From: Fiona Fitzgerald
Sent: 05 March 2025 16:11
To: Planning.Responses
Cc: Jessica Riches
Subject: F/14/24/RES, F/15/24/RES, F/16/24/RES
Attachments: FORD.docx

Please find comments from Environmental Health on the above applications.

Environmental Health **objects** to F/14/24/RES on the basis of both **noise** and **odour**.

F/14/24/RES

Figure 3-1: Measurement Positions

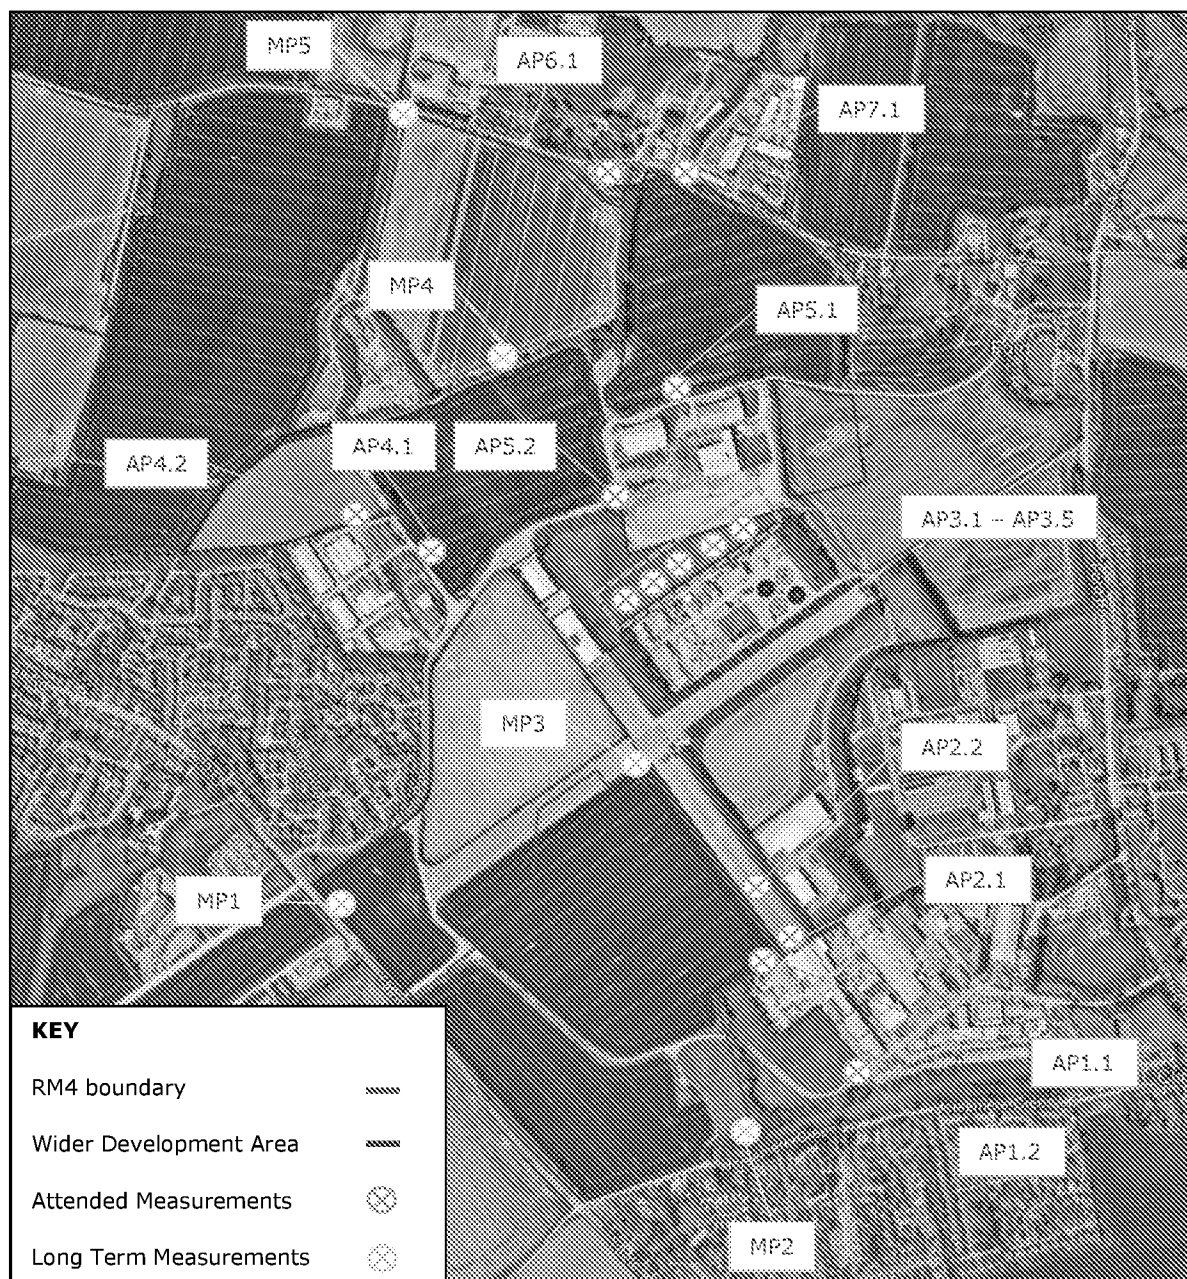
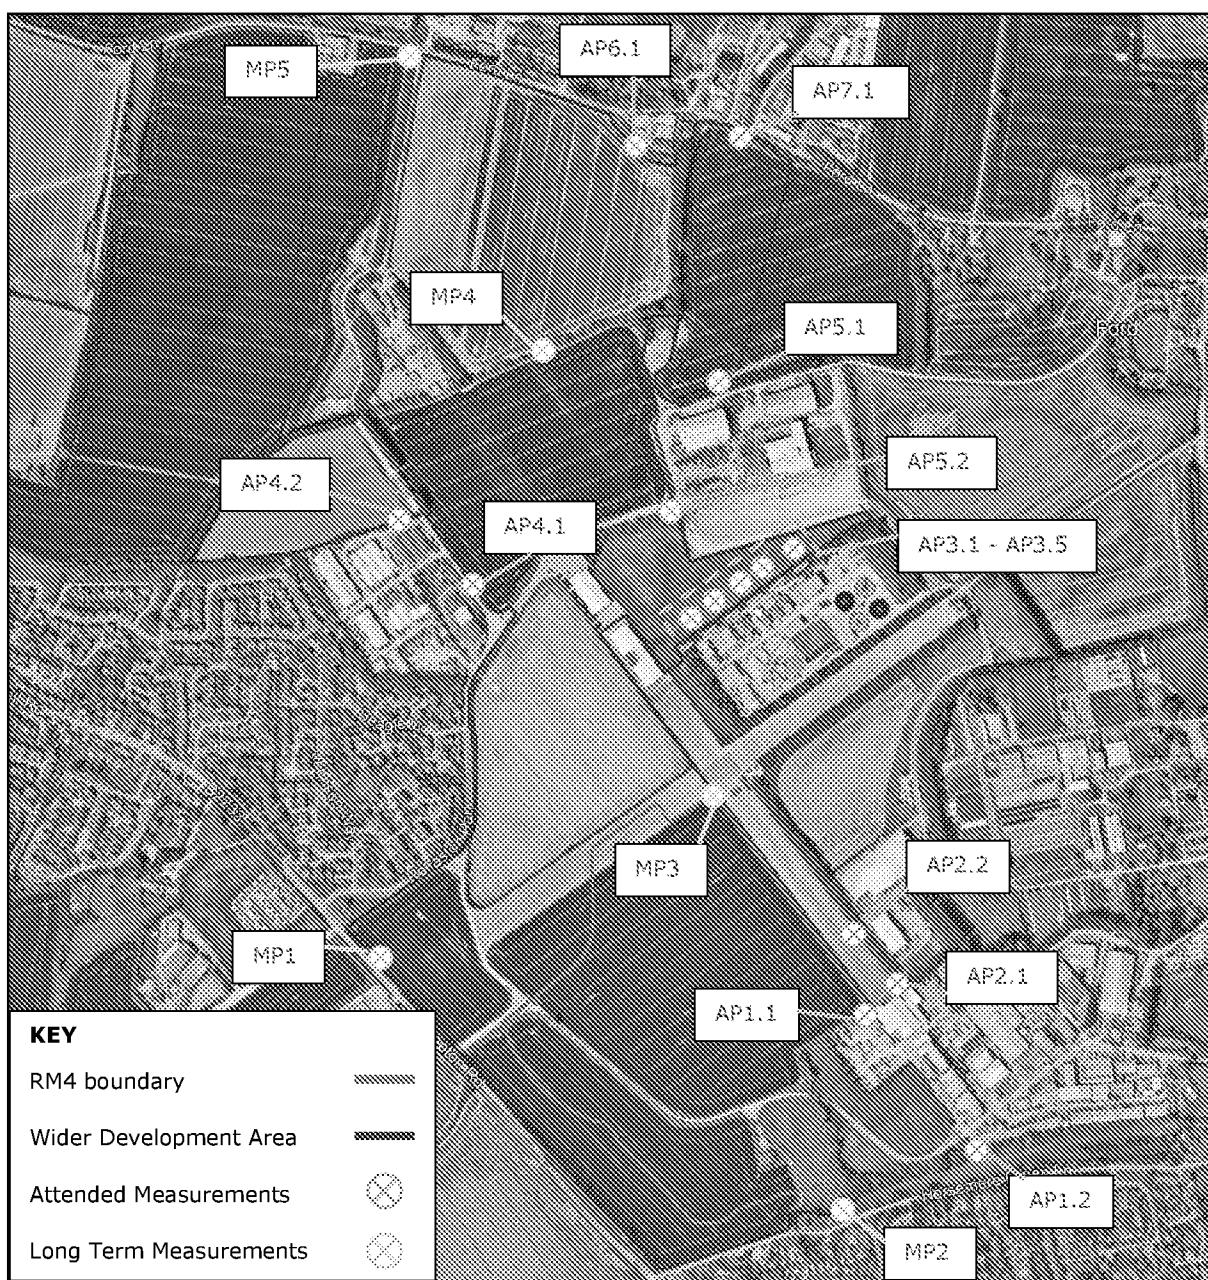
17. Environmental Health would query whether MP5 will give a representative noise environment for those dwellings situated on the north-eastern part of RM1 as the north-eastern location of RM1 is closer to the Wicks Farm development than MP5.
18. It is noted that for the environmental noise survey undertaken between 10 – 14th May 2024, a total of 25 hours were excluded from the survey due to adverse weather. Whilst this clearly cannot be avoided, it has removed 25% of the data, most of which is during the working week. Environmental Health therefore consider that representative background noise levels for the site have not been adequately captured and that further assessment is required to determine whether the data relied upon is robust.

Figure 4-1: Commercial & Industrial Operations

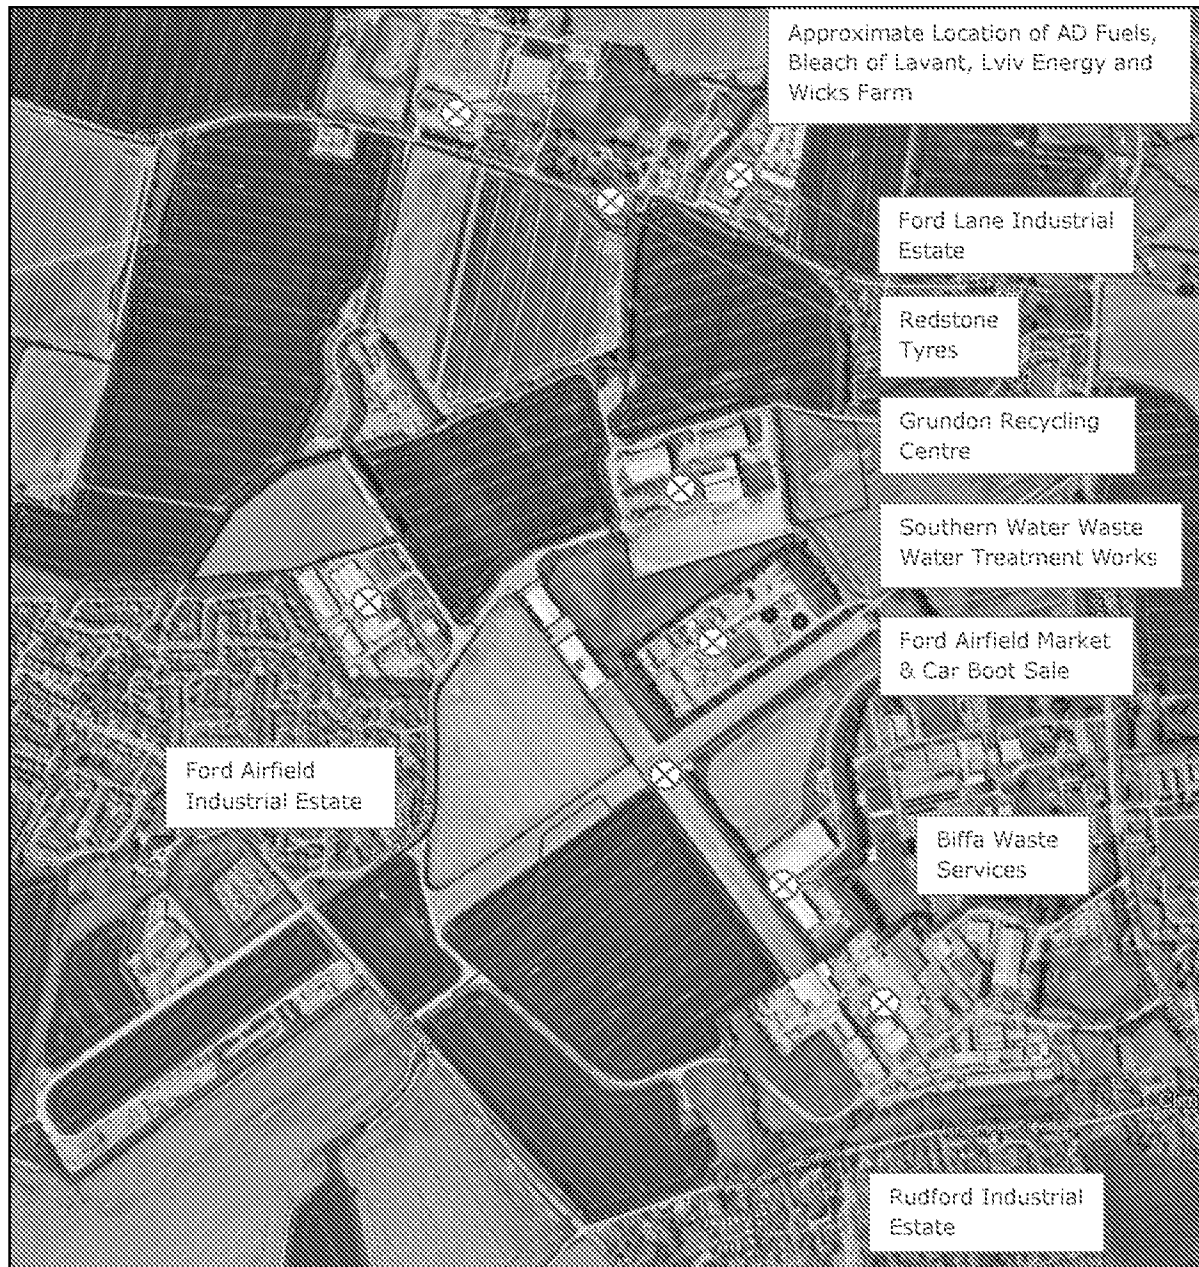
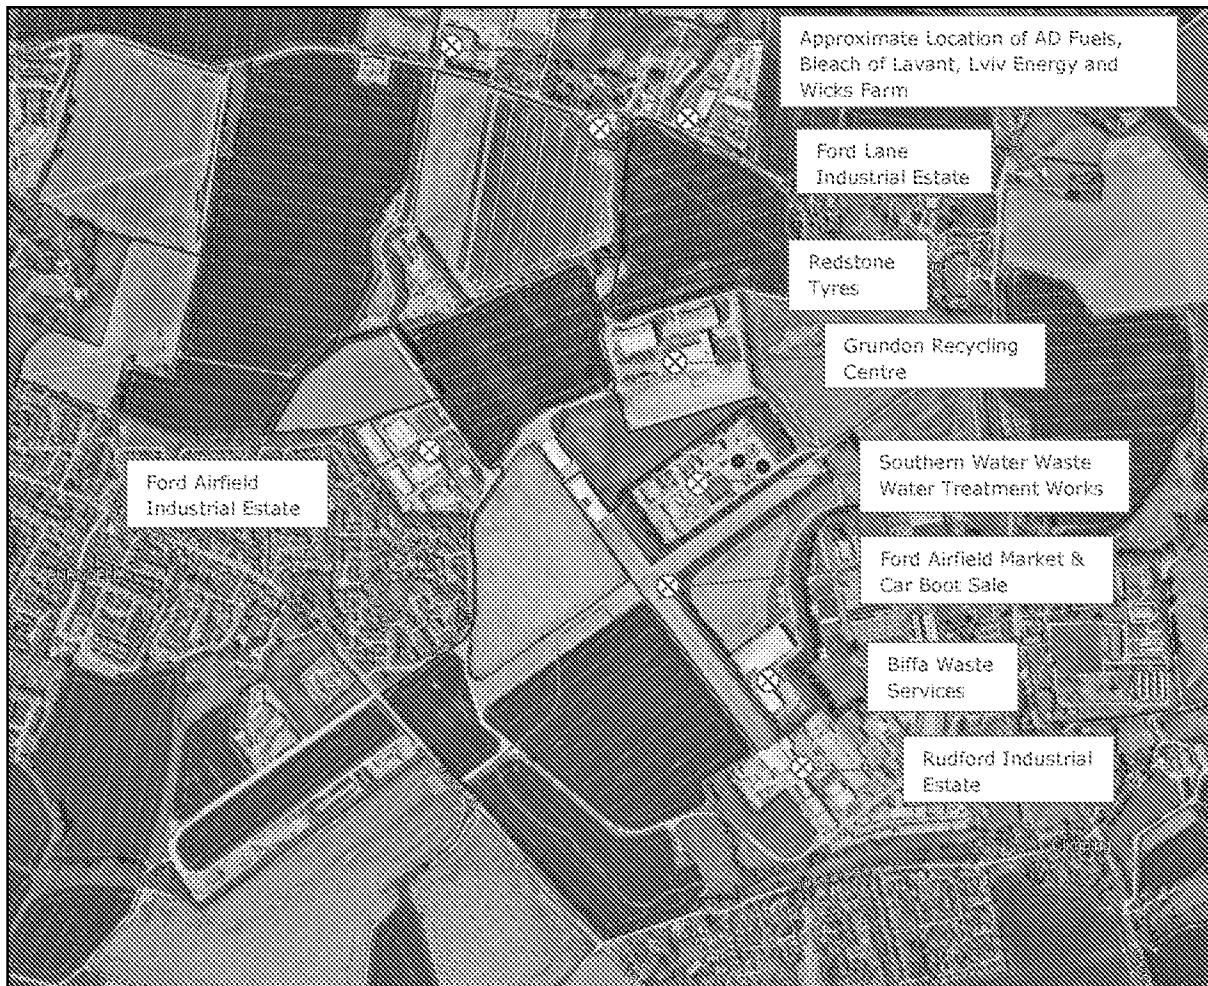
26. Paragraph 4.2 states that noise from commercial and industrial operations have been considered based on publicly available planning and EA permitting information (where

applicable). Environmental Health has concerns that Grundon MRF has therefore not been taken account of due to the applicant considering that the Environment Agency permitting conditions control both noise and odour from the site. Whilst the EA do clearly Permit this site and the permit refers to both noise and odour, this does not mean that noise or odour at a level which could be a Statutory Nuisance or impact on amenity will not occur. This has been brought up repeatedly in comments from Environmental Health in the outline permission, but this appears not to have been taken account of in the application.
